From: Planning
Subject: FW: Wellsprings

From: Lorimer, Elliott <Elliott.Lorimer@lancashire.gov.uk>
Sent: 14 May 2021 14:09
To: Adam Birkett <Adam.Birkett@ribblevalley.gov.uk>
Subject: Wellsprings

6218 - P03	REV
	-

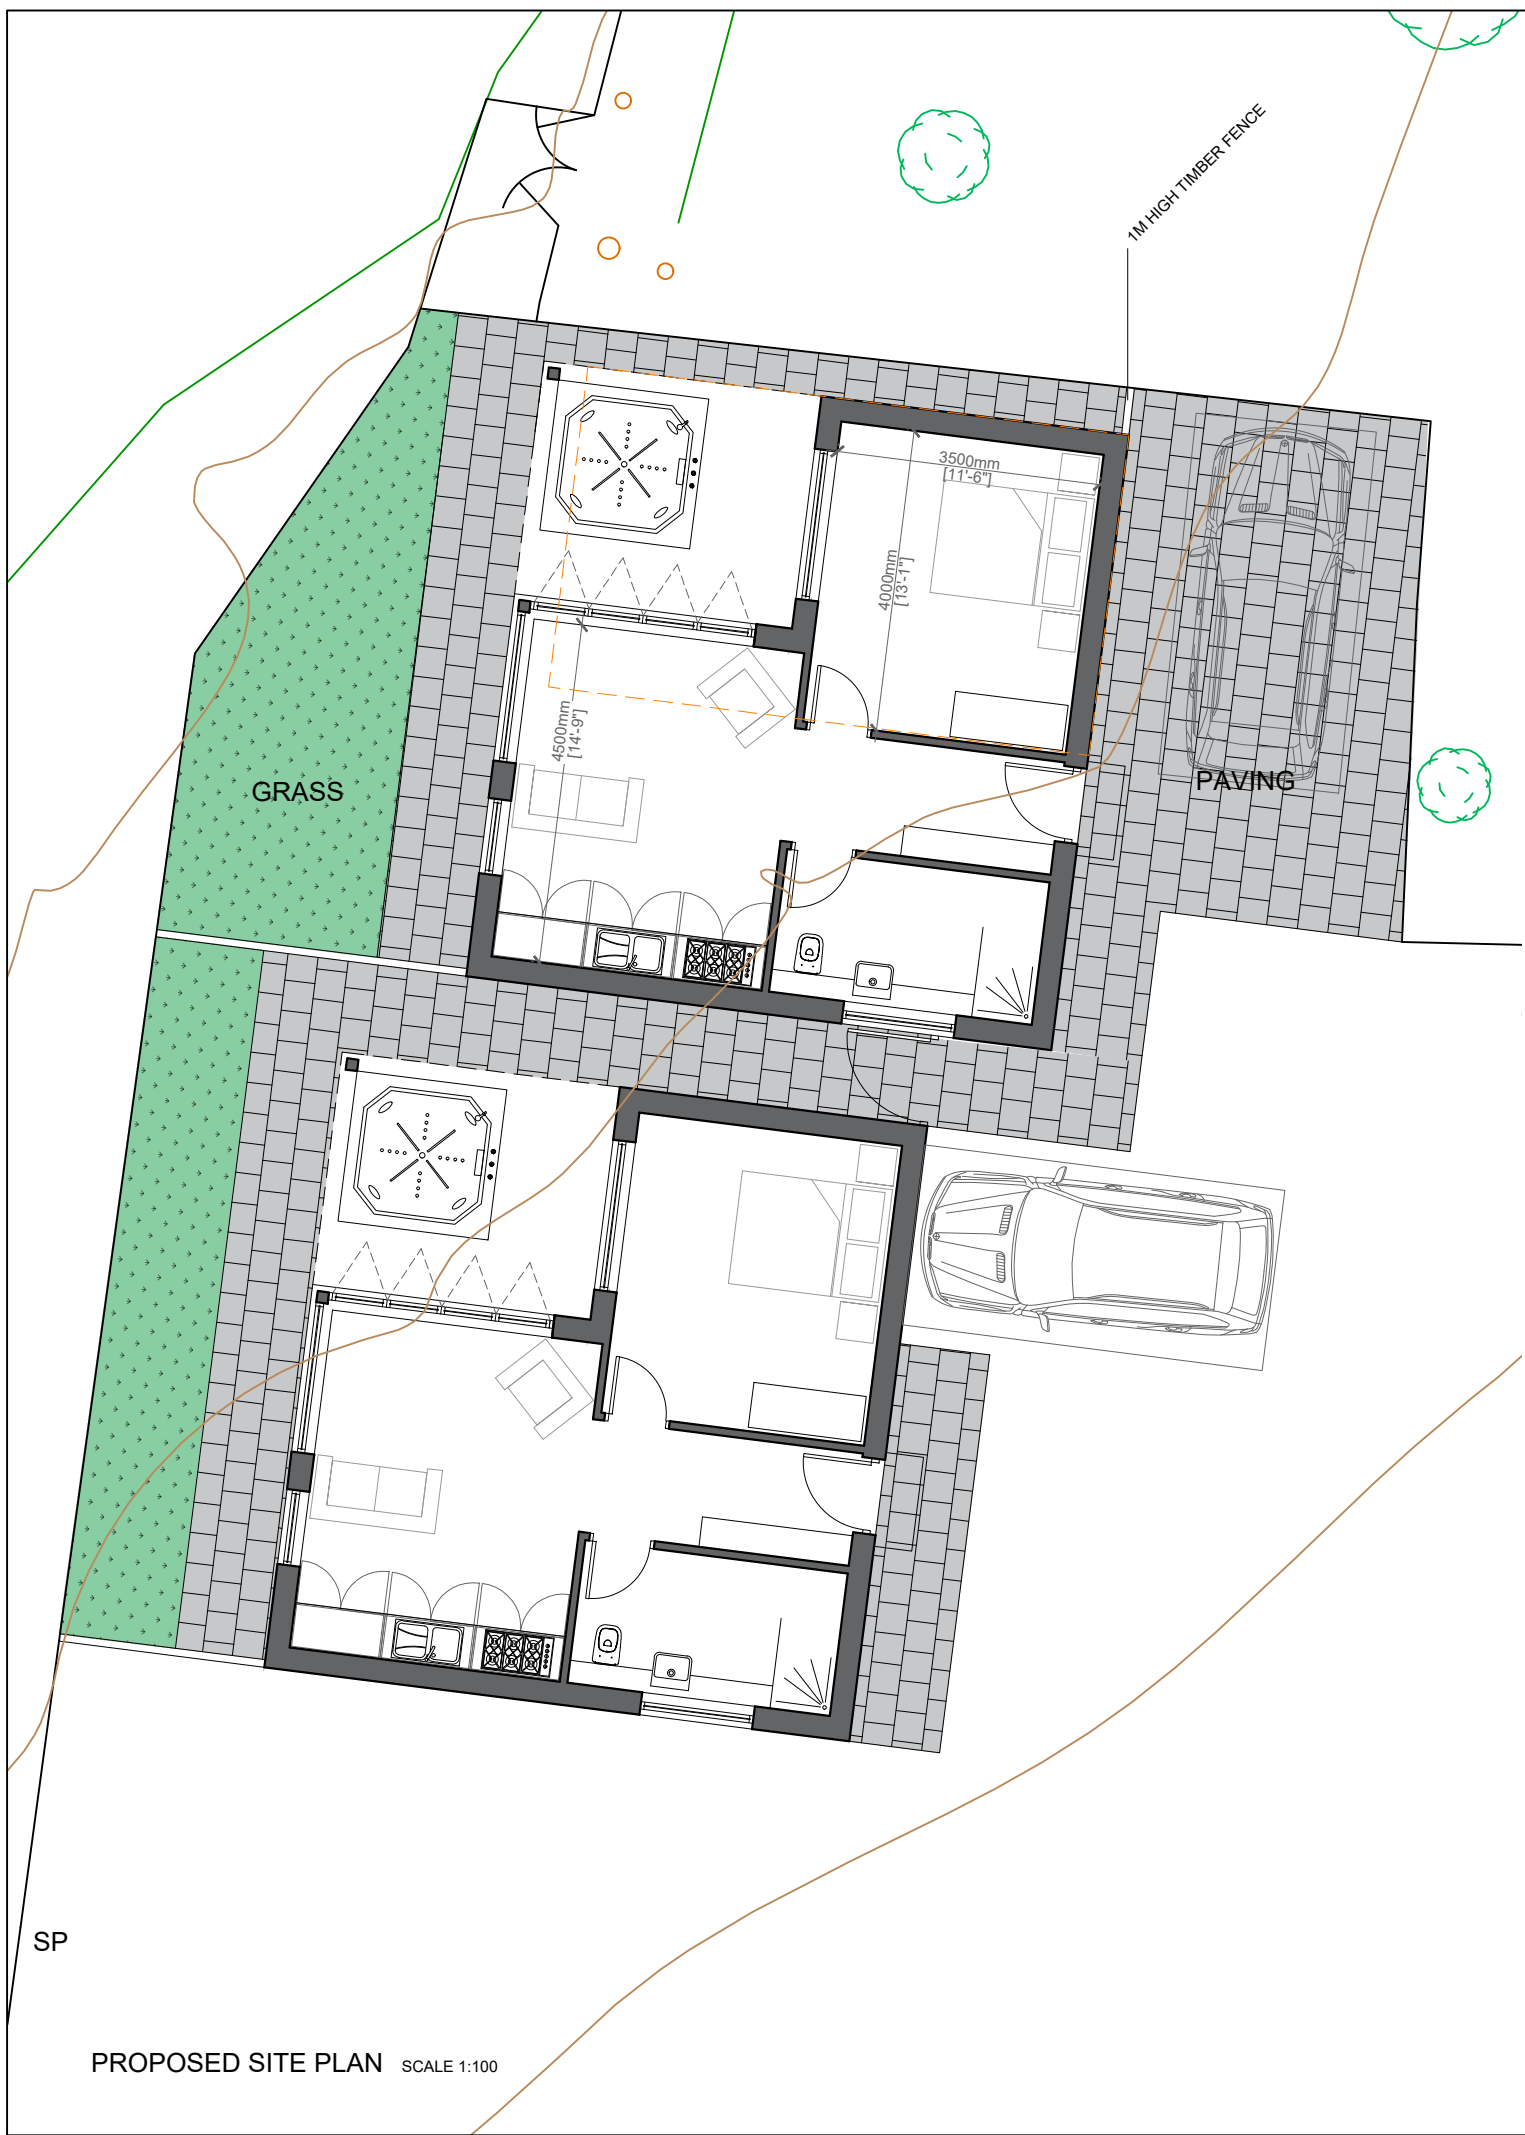
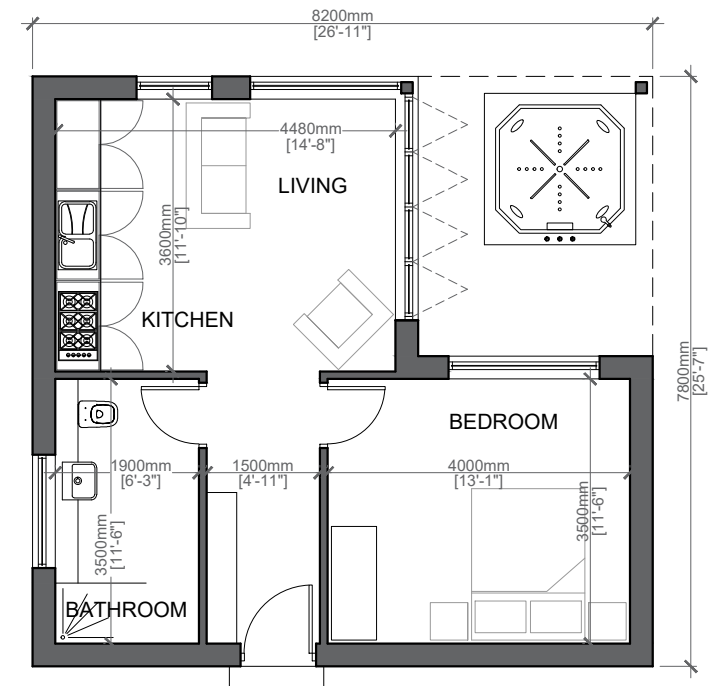
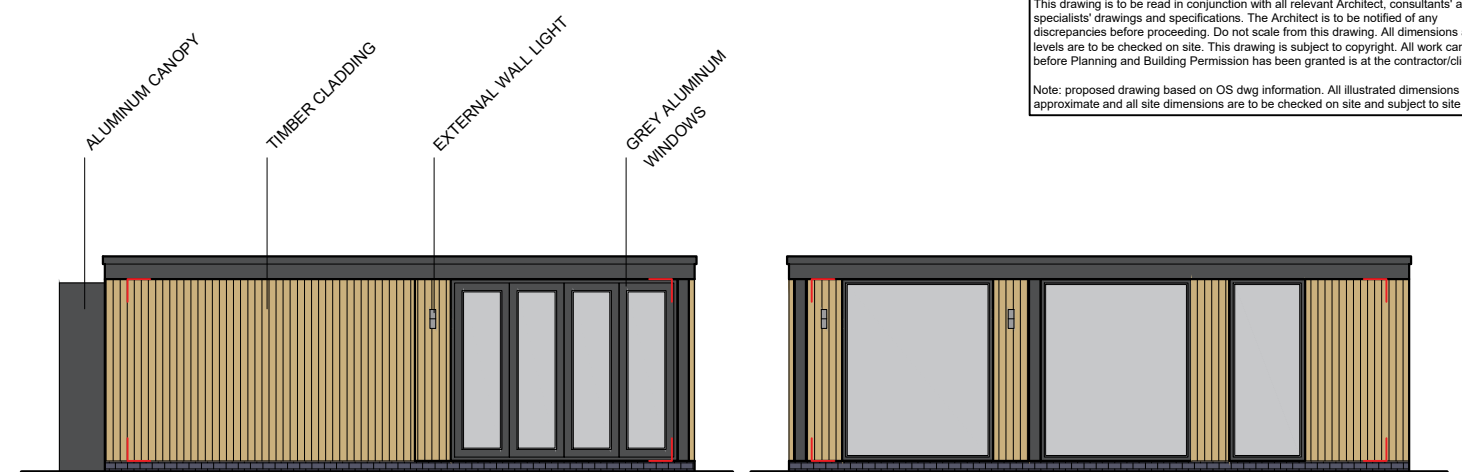
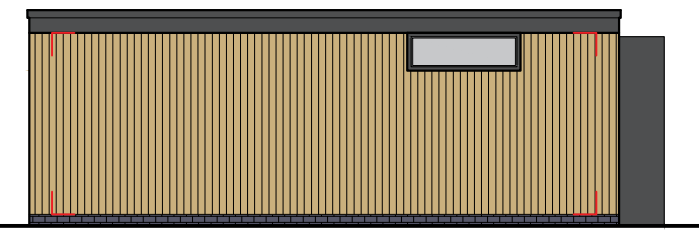
Without such information offering a detailed assessment of the proposal is difficult, but suffice to say my greatest concerns lie with the proposed detached holiday units to the SW of the main building complex.
